From: Amber Willard
Sent: 17 July 2019 14:01
To: Planning.Responses
Subject: FW: y/8/19/hh
Attachments: Hazel Cottage - REV A - Drawing Pack - LDB - 17.07.2019.pdf

Hazel Cottage Y/8/19/HH

PROJECT TITLE Proposed Development at Hazel Cottage Church Lane Yapton Arundel	DRAWING TITLE Proposed Elevations		No	REVISION	DATE
	STATUS Planning Application				
	SCALE 1:100 @ A3	DATE 03.01.2019			
	DRAWN BY DE	DRAWING NO PA-302-06

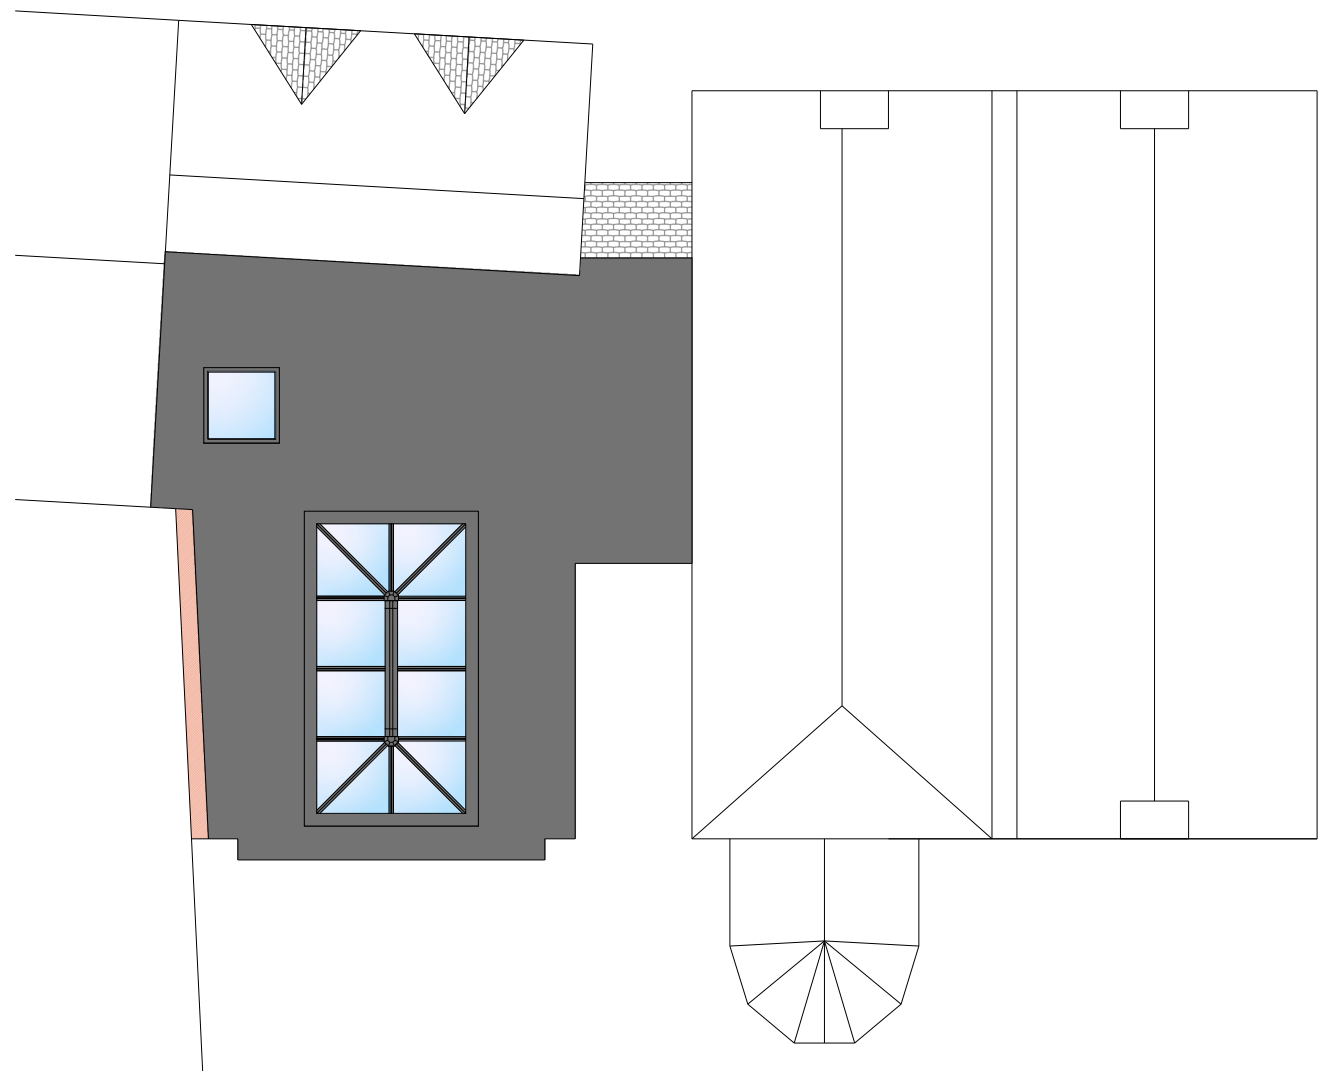
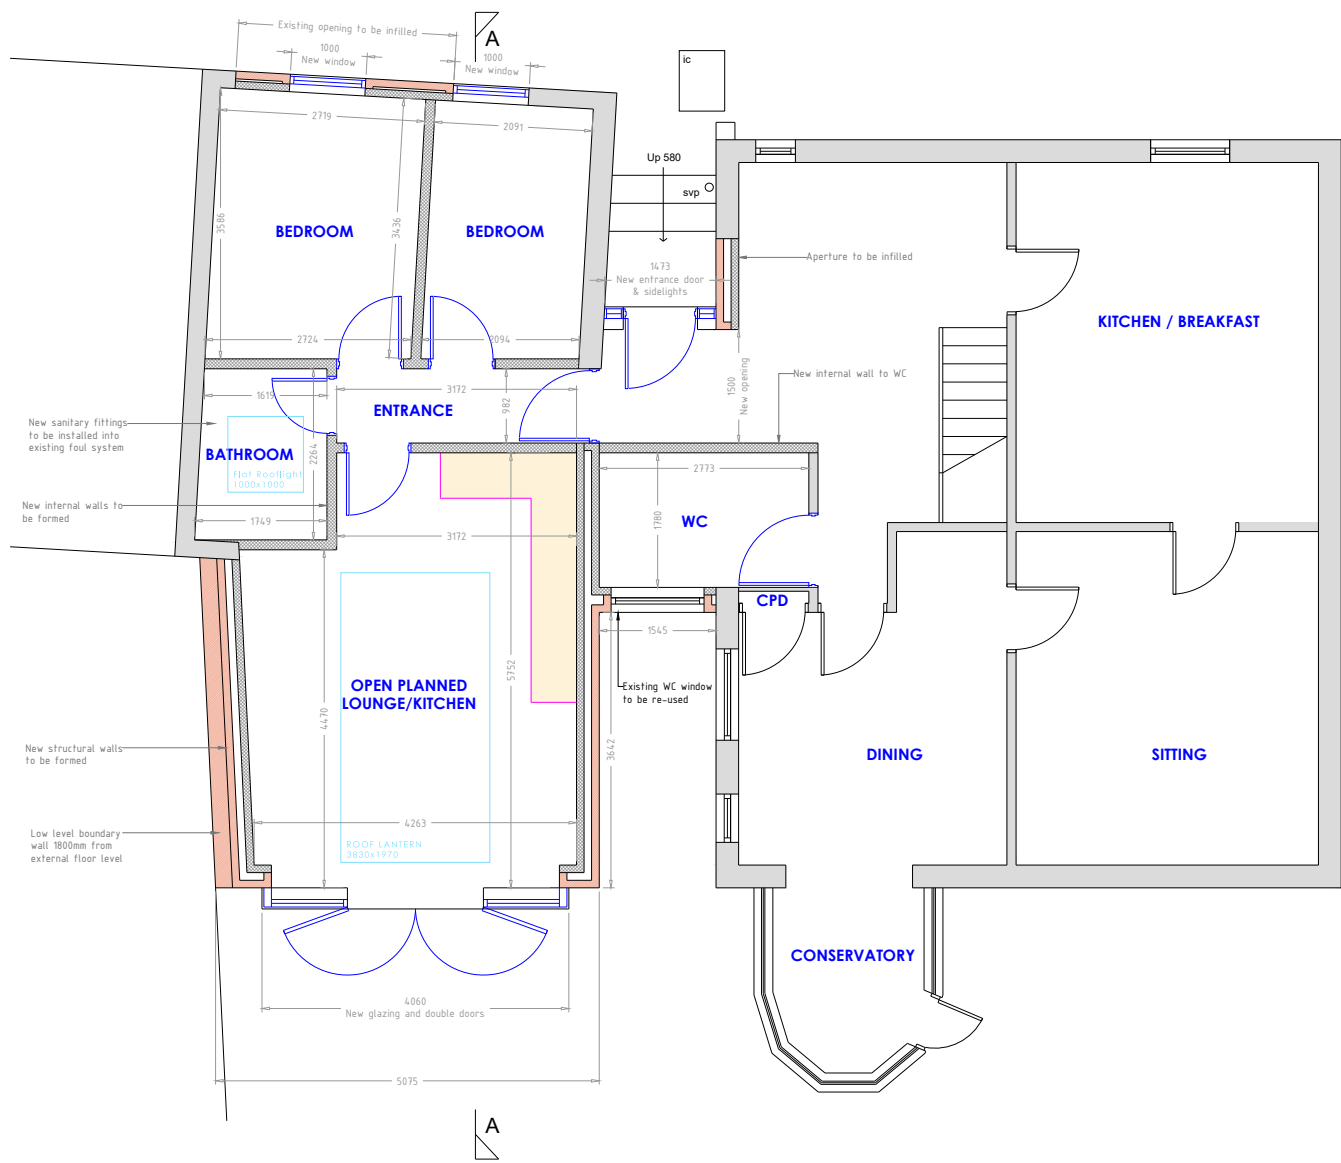
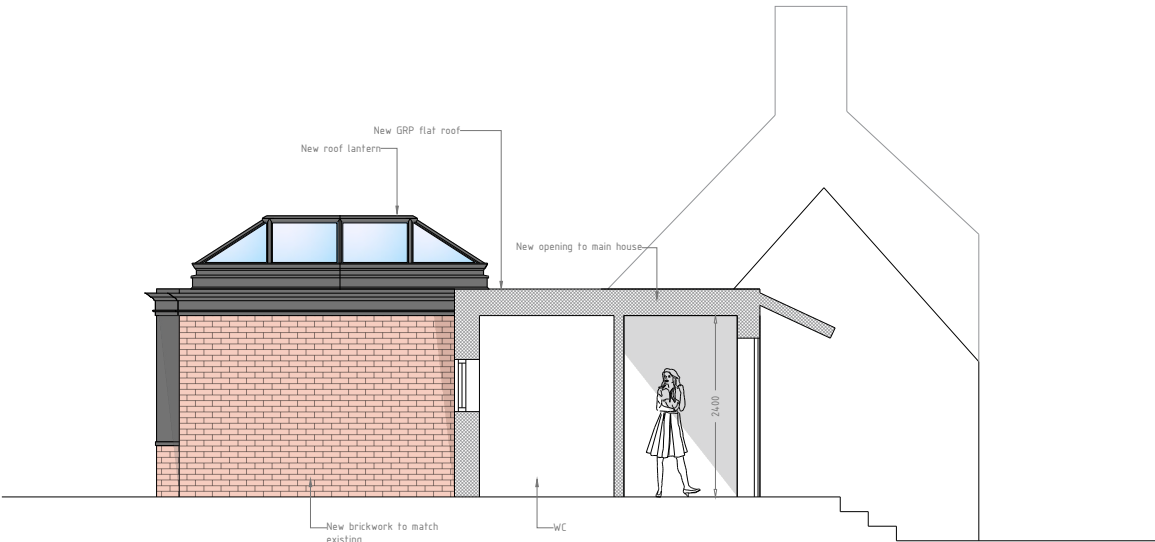
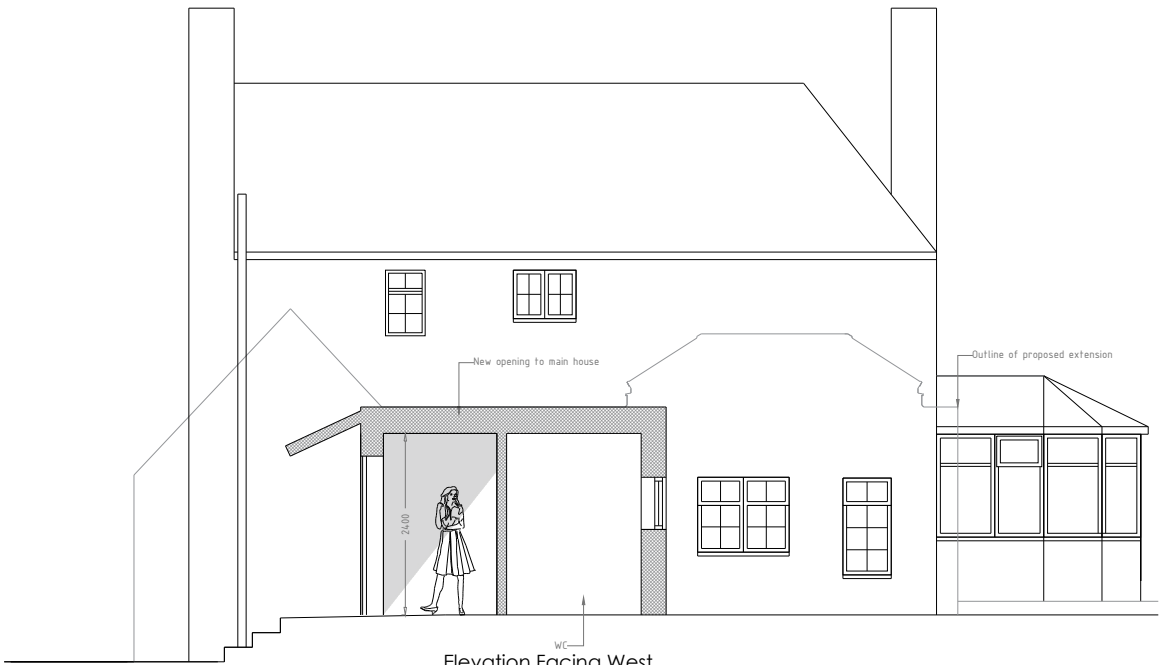
- Do you know the height of the boundary wall to the neighbouring listed building. Will the extension be taller than this and how much by as it is not clear on the plans.
- The low level boundary wall, is this proposed to be built alongside the boundary (listed wall) to separate it as such. If so it seems to create a void and then joins the wall, can you confirm if this is the case. (as shown below).

- The roof light is a dominant feature at around 1m in height and visible from the neighbouring property. Would you be willing to lower this feature?

- Do you know the height of the boundary wall to the neighbouring listed building. Will the extension be taller than this and how much by as it is not clear on the plans. **THE BOUNDARY WALL IS 2.250M HIGH. THE PROPOSED EXTENSION IS 2.975M HIGH.**
- The low level boundary wall, is this proposed to be built alongside the boundary (listed wall) to separate it as such. If so it seems to create a void and then joins the wall, can you confirm if this is the case. (as shown below). **YES, THIS IS TO KEEP THE MAIN STRUCTURE AND ANY ROOF OVERHANG AWAY FROM THE BOUNDARY WALL**

- The roof light is a dominant feature at around 1m in height and visible from the neighbouring property. Would you be willing to lower this feature? **YES, THIS WOULD BE ACCEPTABLE. WE COULD PROPOSE A FLAT ROOF ROOFLIGHT:**

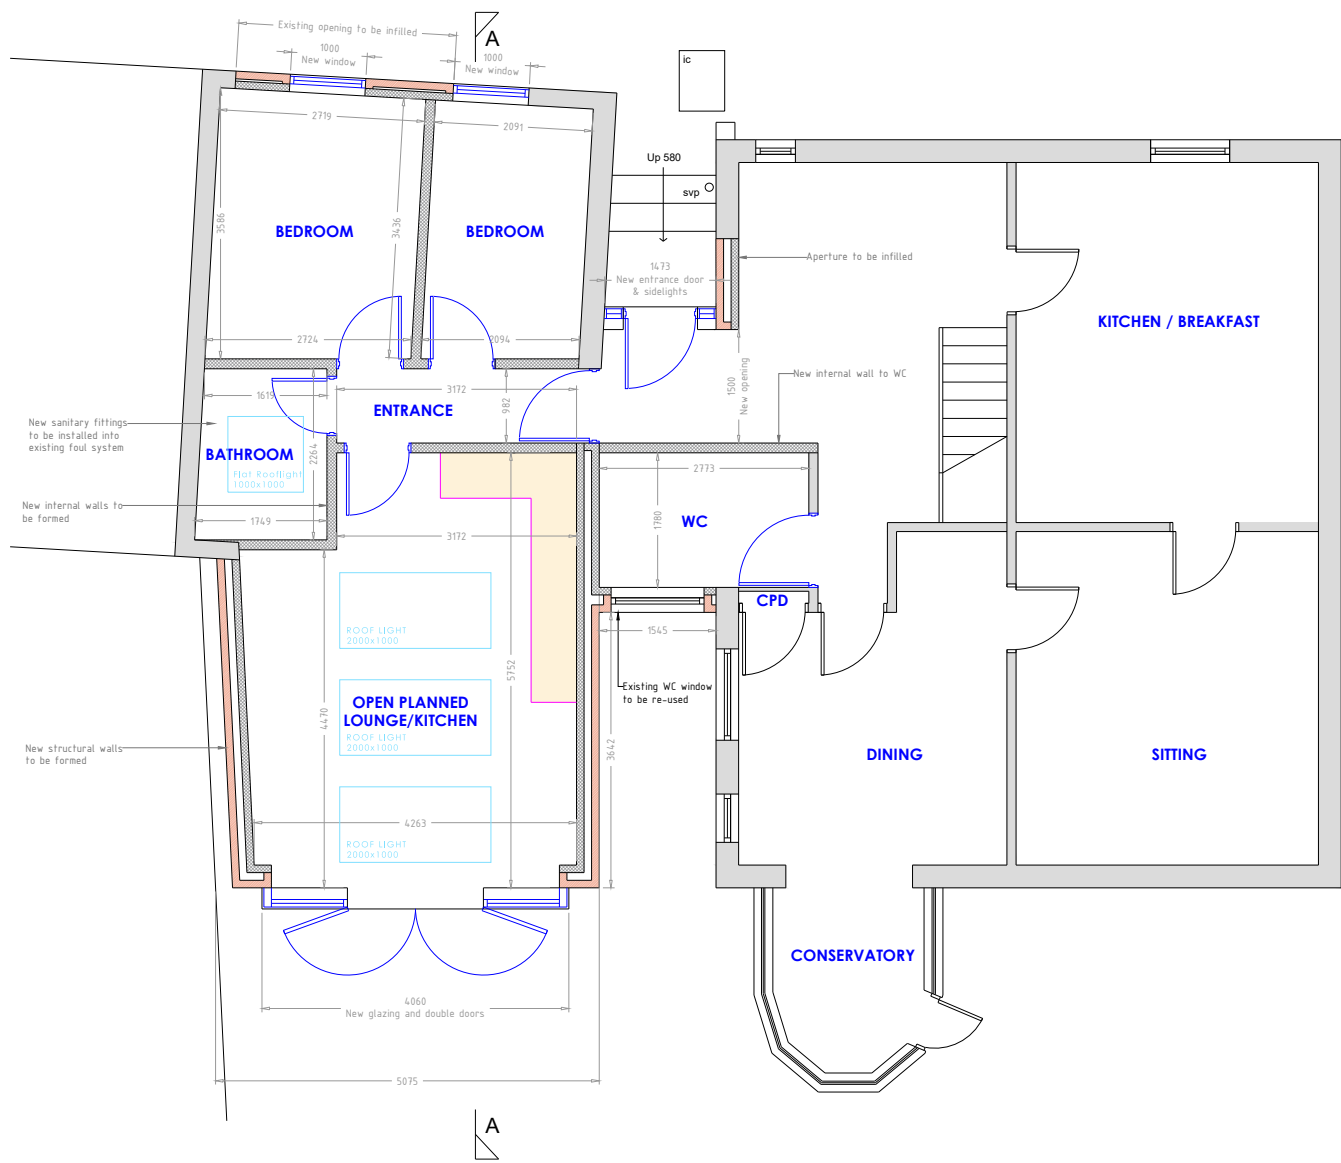
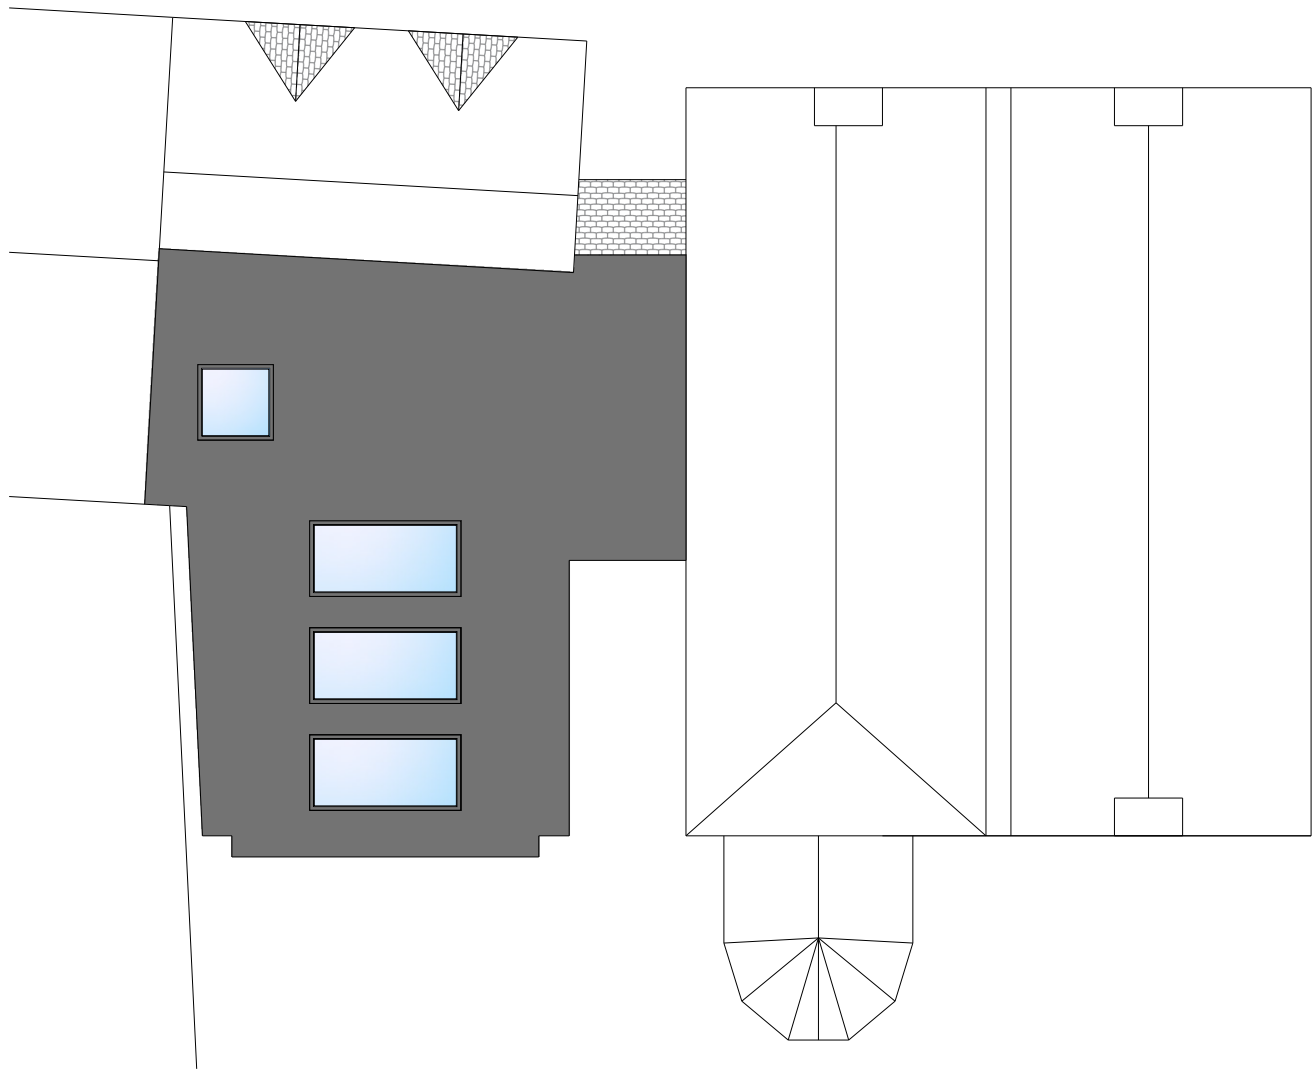
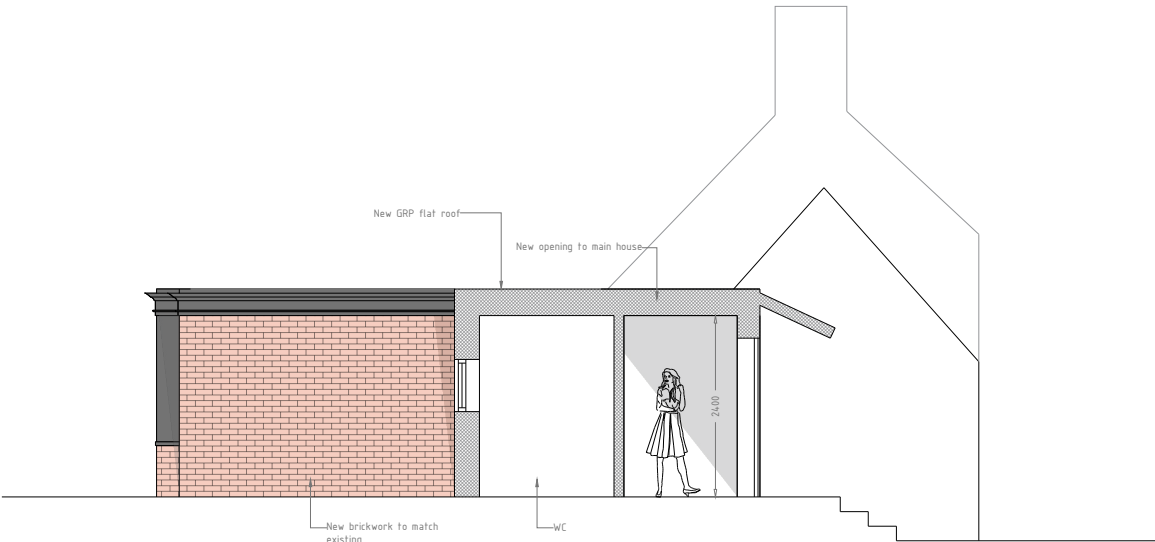
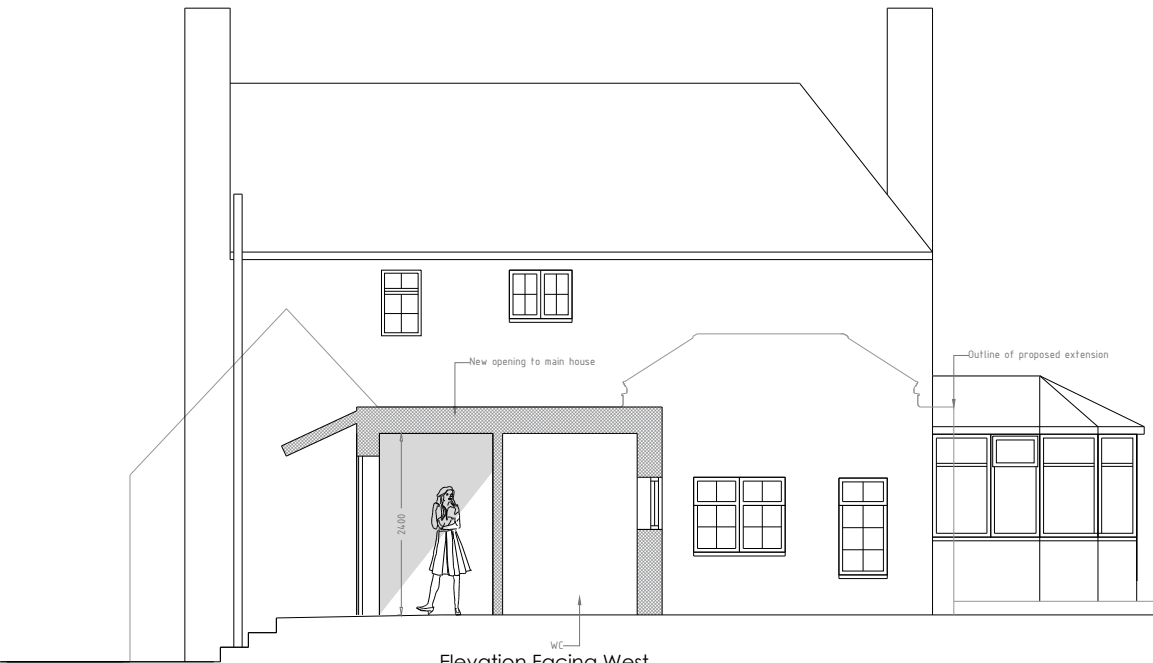
Please are we able to get amended plans to show the alteration to the rooflight and to the wall.

We are still concerned about the low level wall that is to be built. We feel to ensure there is no damage to the boundary listed wall, would you propose to not construct this and leave a small gap between the extension and the wall.
